Installation of two outfalls at the Saltbox Development, Shripney Road

EPR-JB3756SF

Permit reference: EPR-JB3756SF- Installation of two outfalls at the Saltbox Development, Shripney Road

From: PSO West Sussex <PSO [REDACTED]>
Sent: 02 December 2020 10:43
To: Mike Griffin_archive
Cc: David Gallimore; Brian McAllan; Kendall, Annabelle
Subject: RE: [Hydrock: 13319_1-SBNO] RE: EPR/JB3756SF - Installation of 2nr outfalls at Shripney Road, Saltbox - Shripney Manor Ditch___further information and fees required

CLIENT		
LANDLINK ESTATES		
PROJECT		
SALTBOX BOGNOR REGIS		
TITLE		
HEADWALL DETAILS		
HYDROCK PROJECT NO. C-13319-C		SCALE @ A1 1:25
STATUS DESCRIPTION AS BUILT ISSUE		STATUS A
DRAWING NO. (PROJECT CODE-ORIGINATOR-ZONE-LEVEL-TYPE-ROLE-NUMBER) SAL-HYD-00-ZZ-DR-C-7110		REVISION C04

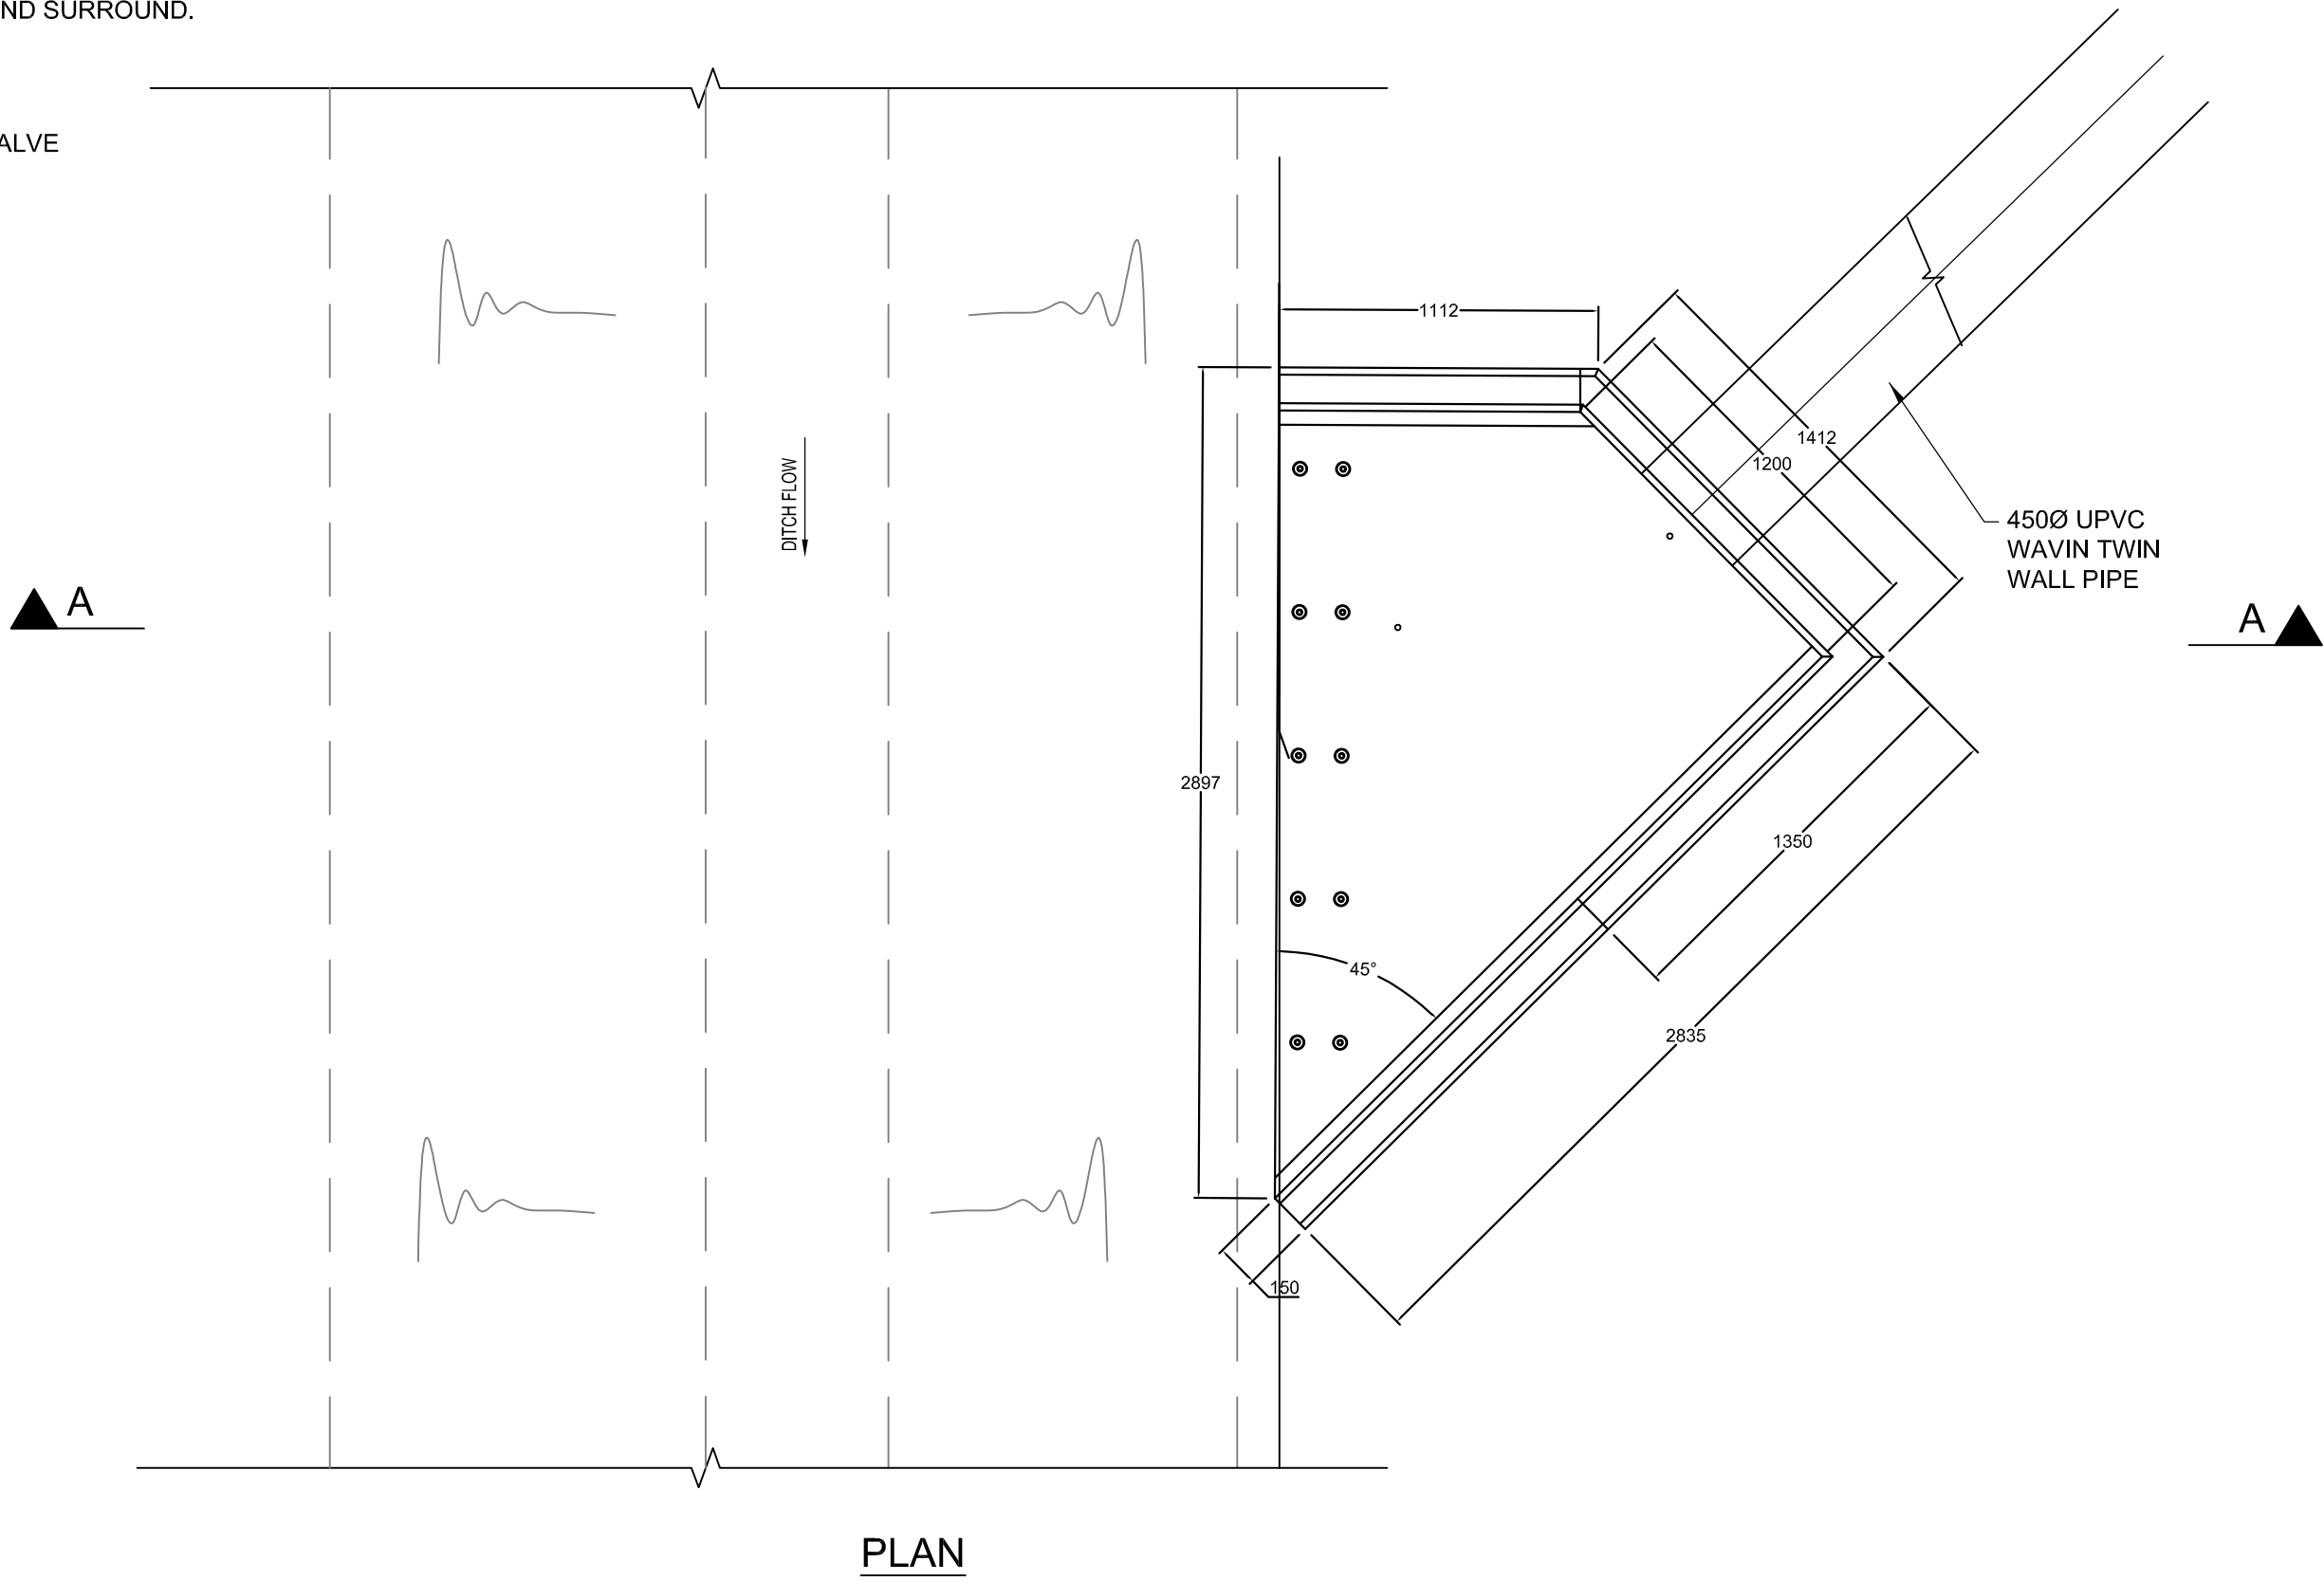
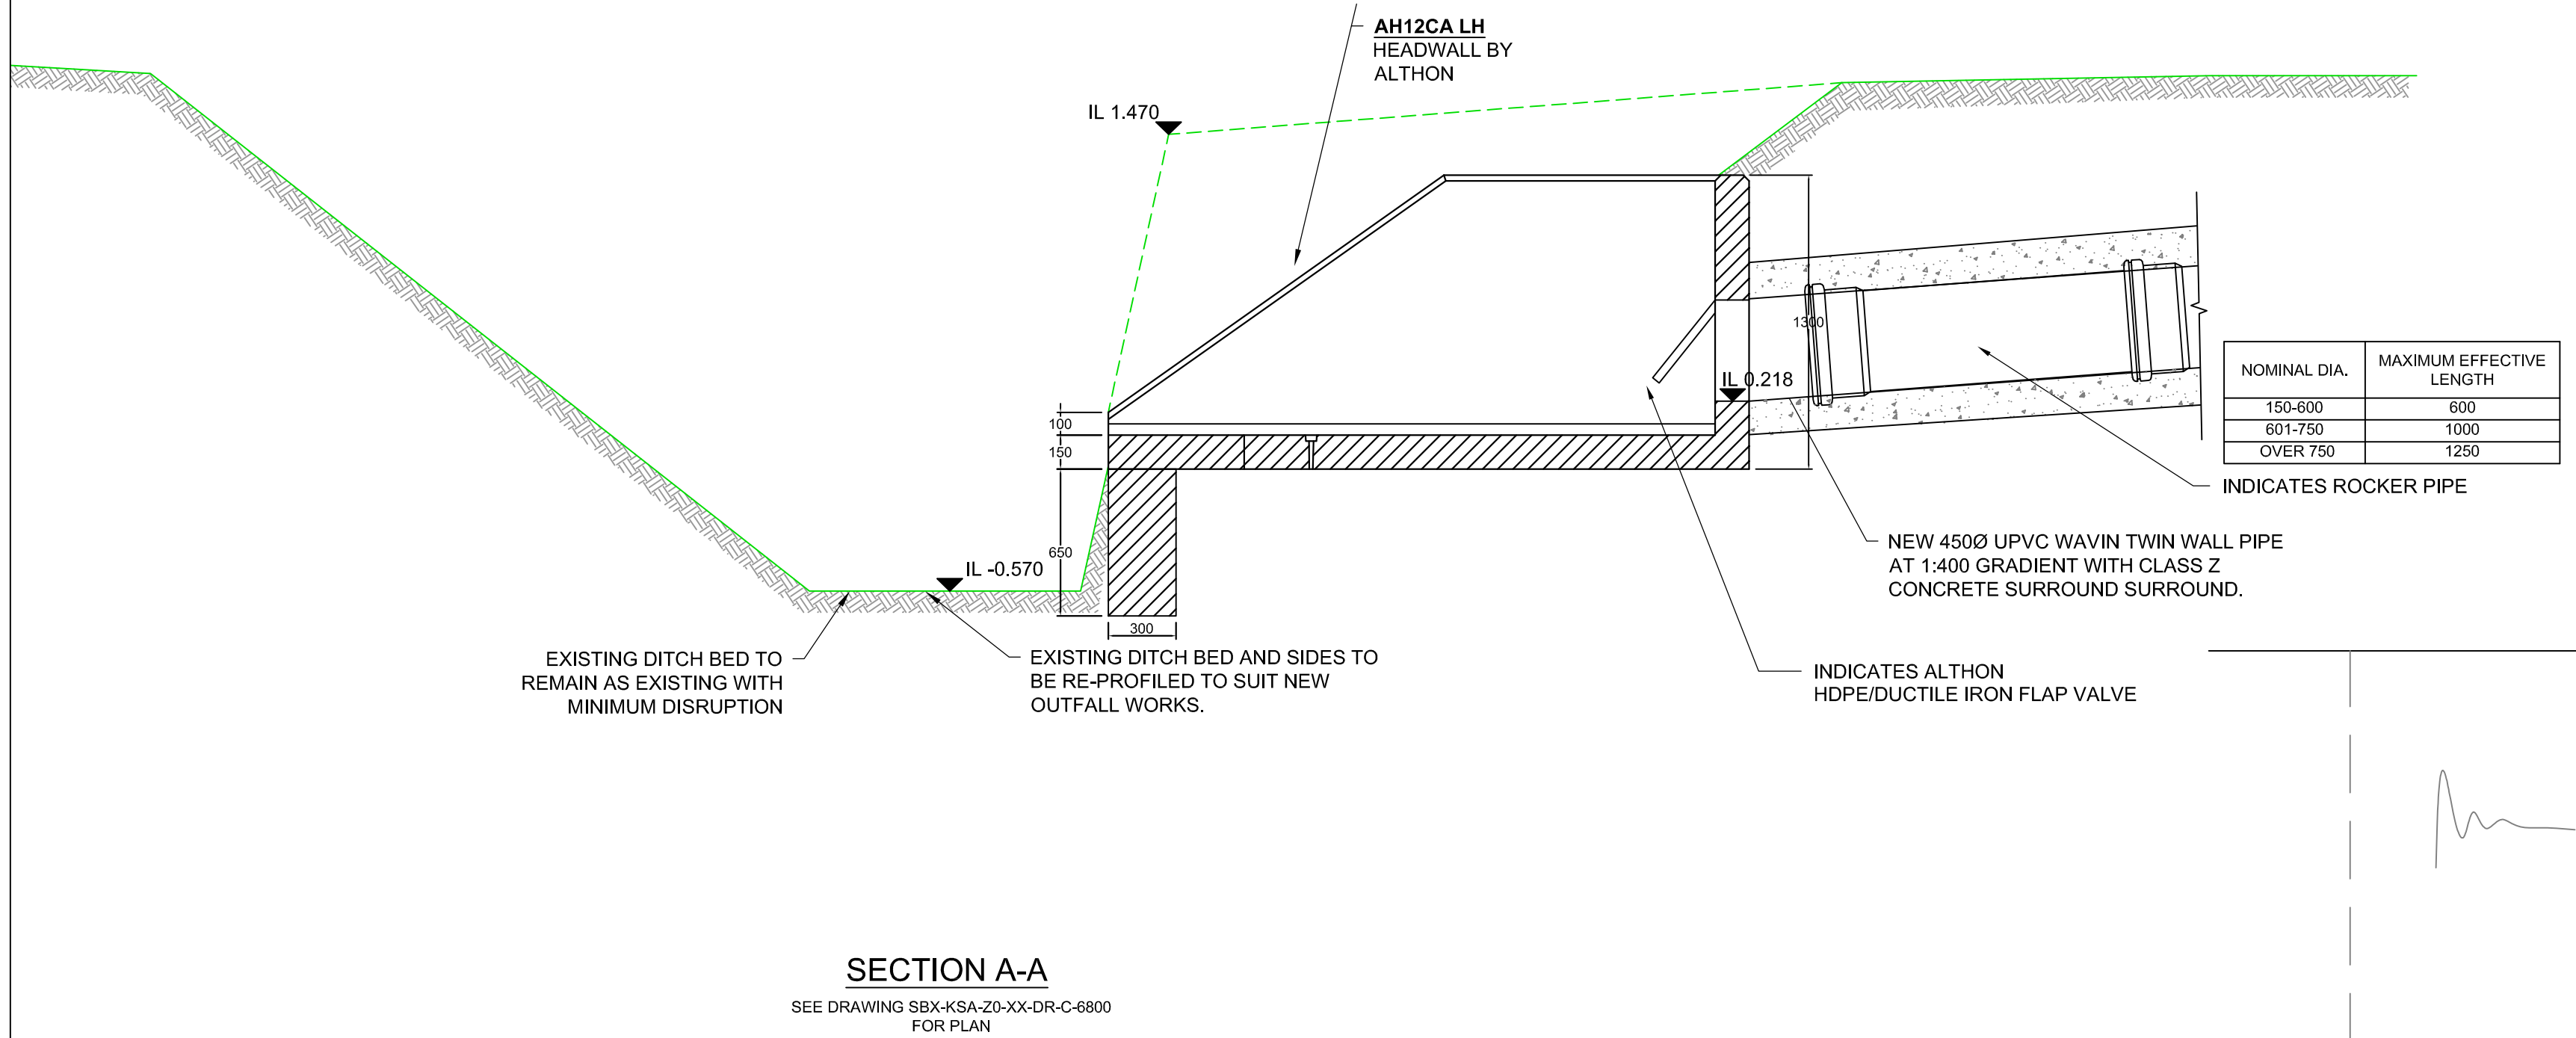
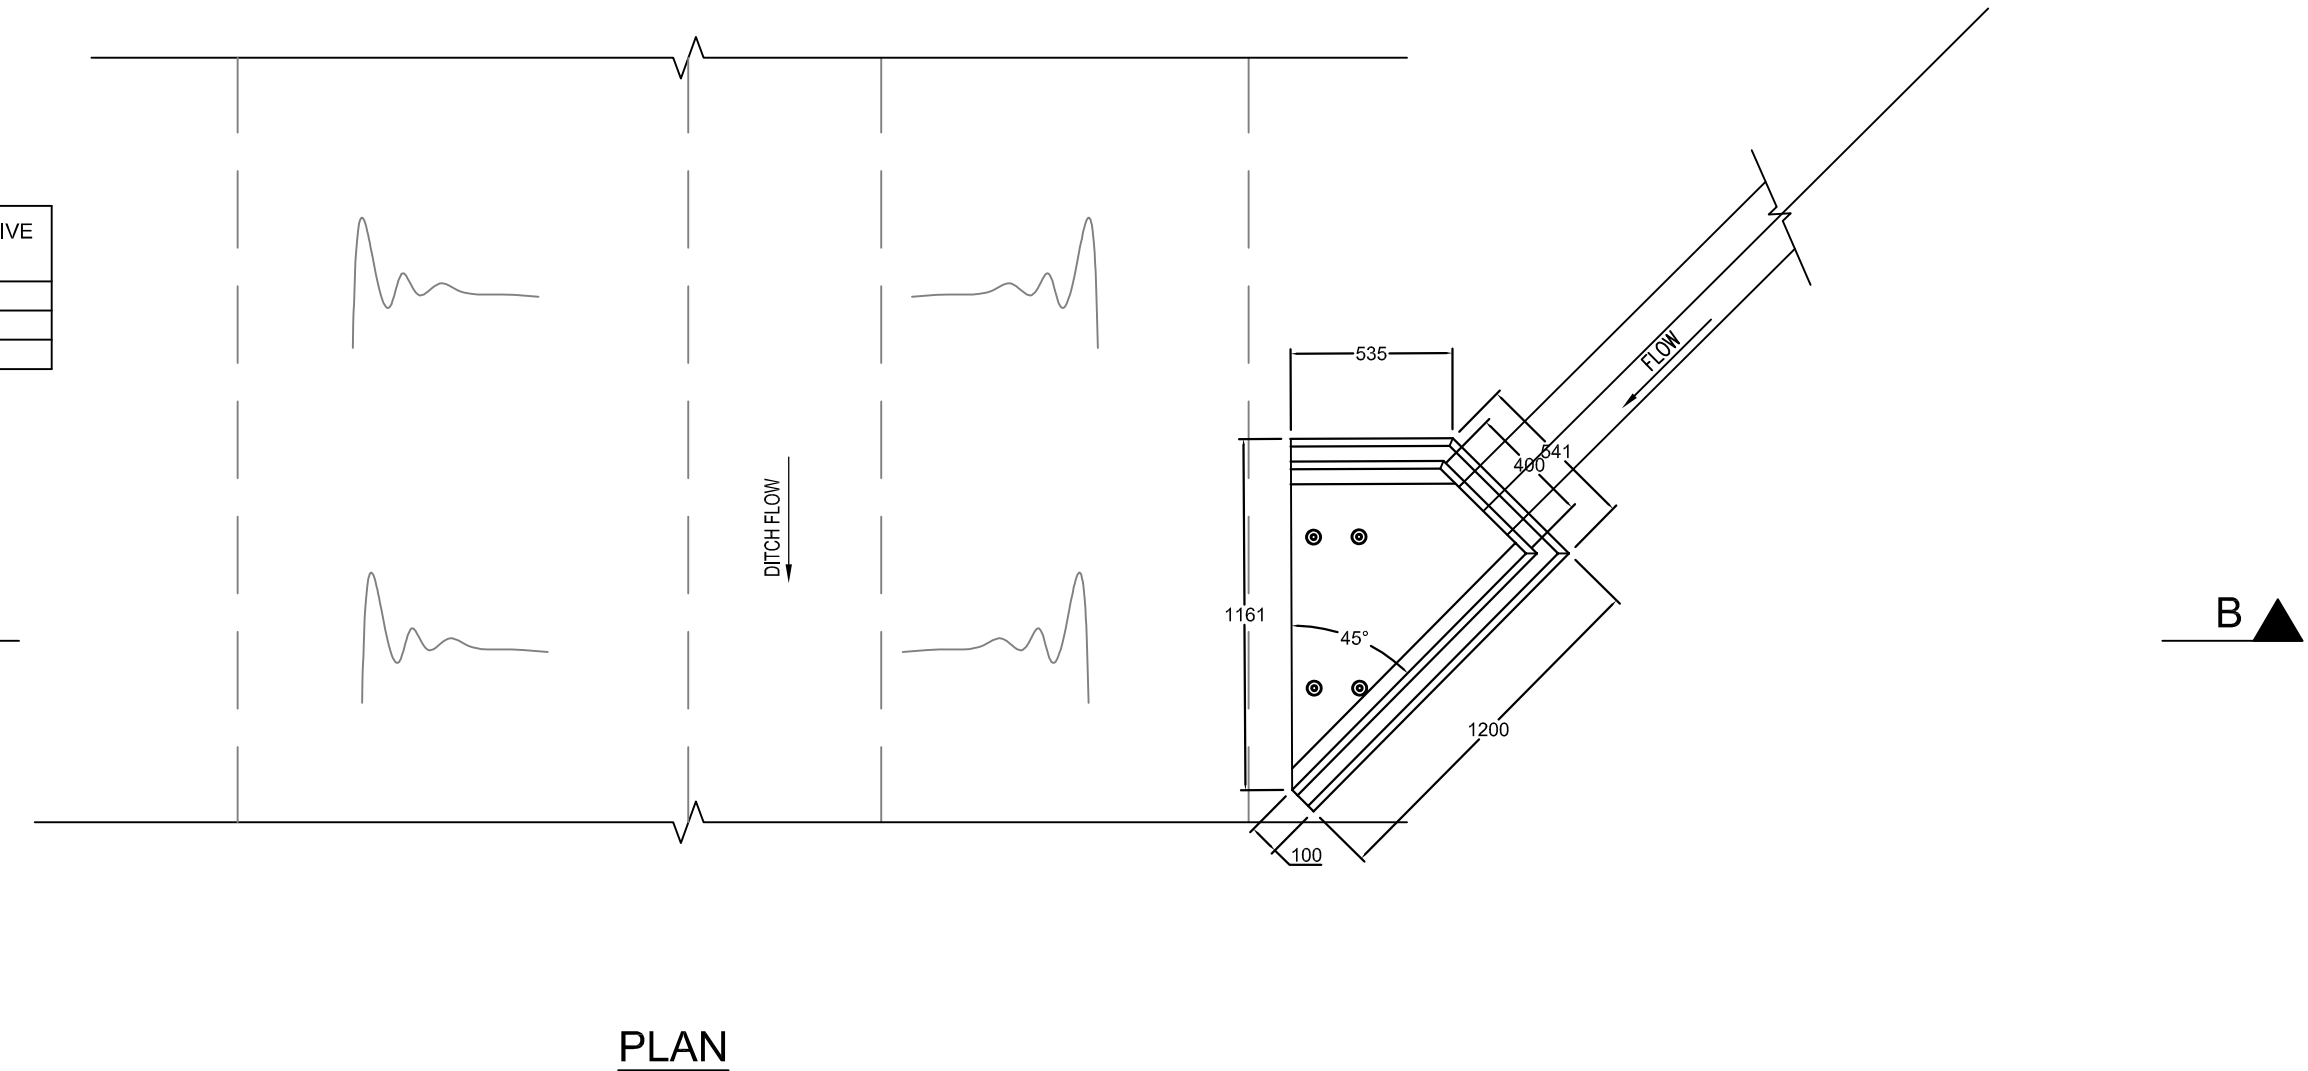
- An updated Form A which clearly defines the operator and agent for the permit;
- Further details regarding the angle of the proposed outfalls and mitigation measures in the form of bank protection;
- A revised method statement which provides greater detail as to the mitigation of ecological and environmental aspects of the site location

I did note some inconsistencies in the method statement which still shows the angle of the proposed headwalls at a 90 degree angle, but I have noted the changes on the main site drainage strategy and cross sections plans.

Regarding the bank protection mitigation measures, our Fishers, Geomorphology and Biodiversity team have confirmed that if flows are restricted by hydrobreaks to the levels specified, and initial discharge is onto concrete chamber then we would have no need for lining the bank with mattress protection.

We are reviewing the angle of headwall with the contractor and will update / re-issue the details accordingly.

With the adjustment in the headwall angle and the relatively low discharge rates it is considered to lessen the impact of the outflow on the adjacent bank. We are therefore proposing to remove the erosion blanket from the proposals (from what is currently shown on the attached). This will also reduce the ecological impact of the works during construction. We trust that this will be acceptable.
